Part change of use of ground floor & formation of a first floor rear extension to create 2 No. self-contained studio flats with associated refuse/recycling & cycle store (re-submission following BR/233/19/PL)

77 Aldwick Road Bognor Regis

Thank you for your internet representation made on 30th March 2020 which has been recorded as '**an objection**' with the comments as follows:

Drawing
EXISTING & PROPOSED
ELEVATIONS

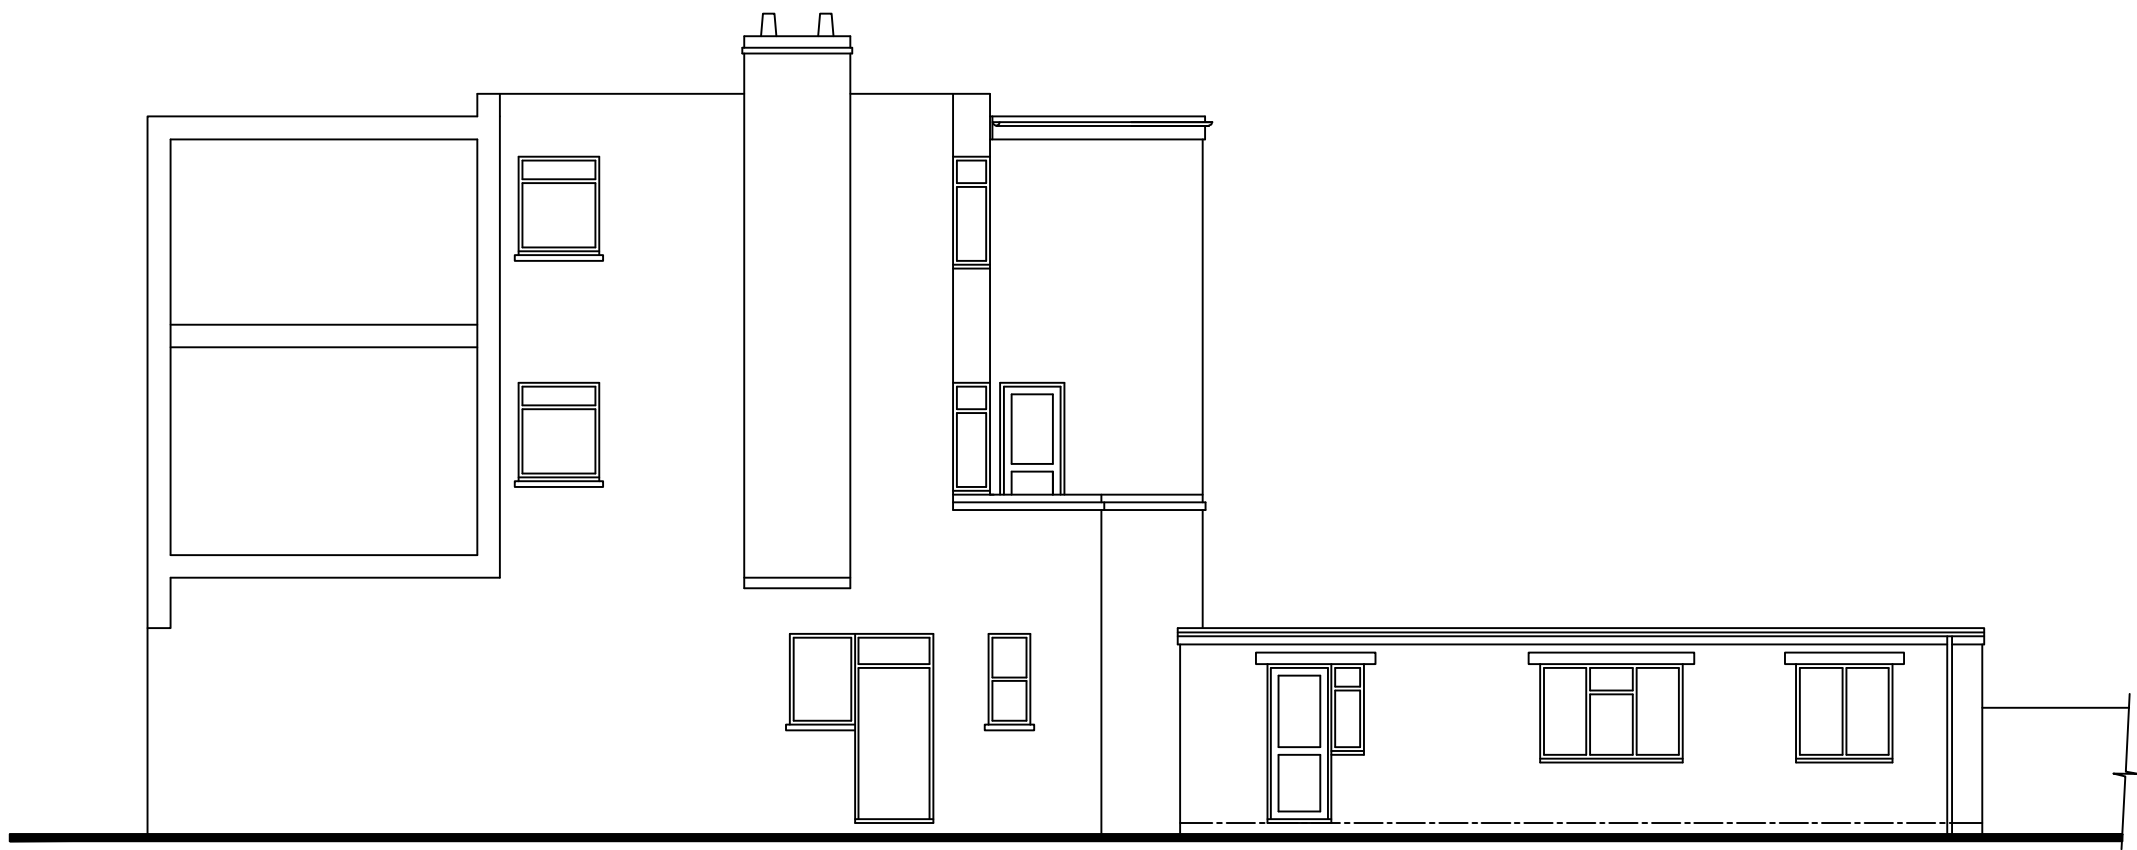
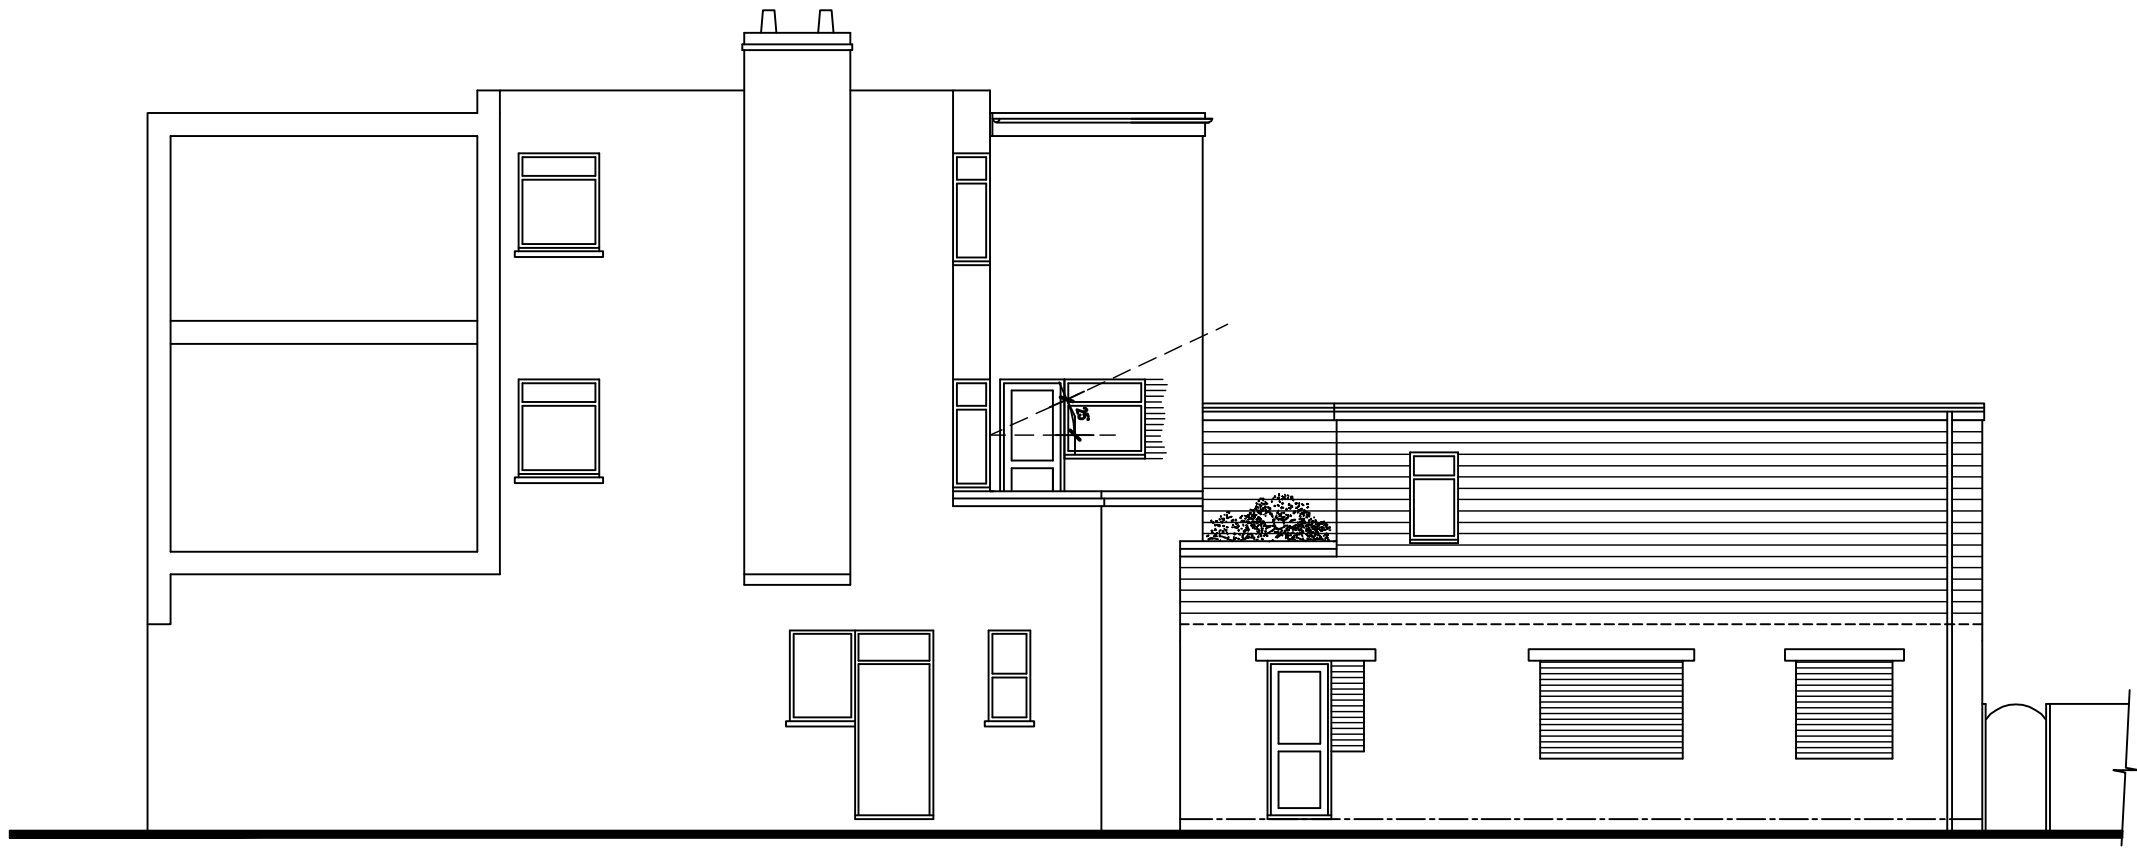
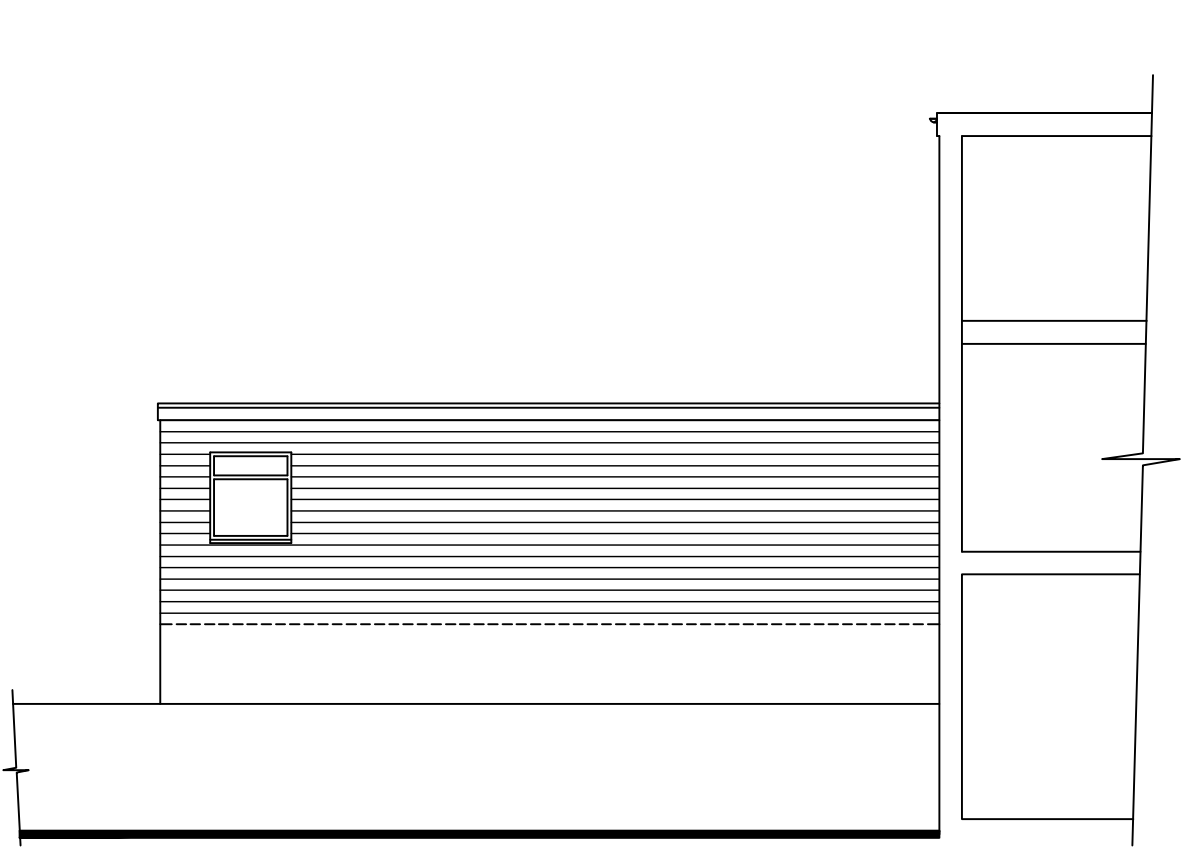
*I totally object to this application as it is still in breach of our privacy overlooking our garden and depriving us from light so much in need in our ground floor flat.  
The applicant's existing property is already poorly maintained with drains left unsorted and leaking for months resulting in front of our flat constantly dump and flooded. Also another big issue made by his tenant which is feeding birds, causing horrendous nuisance and leaving all area contaminated with tons of birds drops has been ignored for months. I honestly cannot see more flats managed by this landlord and I am dreading of the results of such poor maintenance on our property.  
On top of that this application will deprive us and other Aldwick residents from so much needed and popular dry cleaning service. We are already left without most essential services such as Post Office and Pharmacy. Losing another very important service would be the last straw for Aldwick residents.
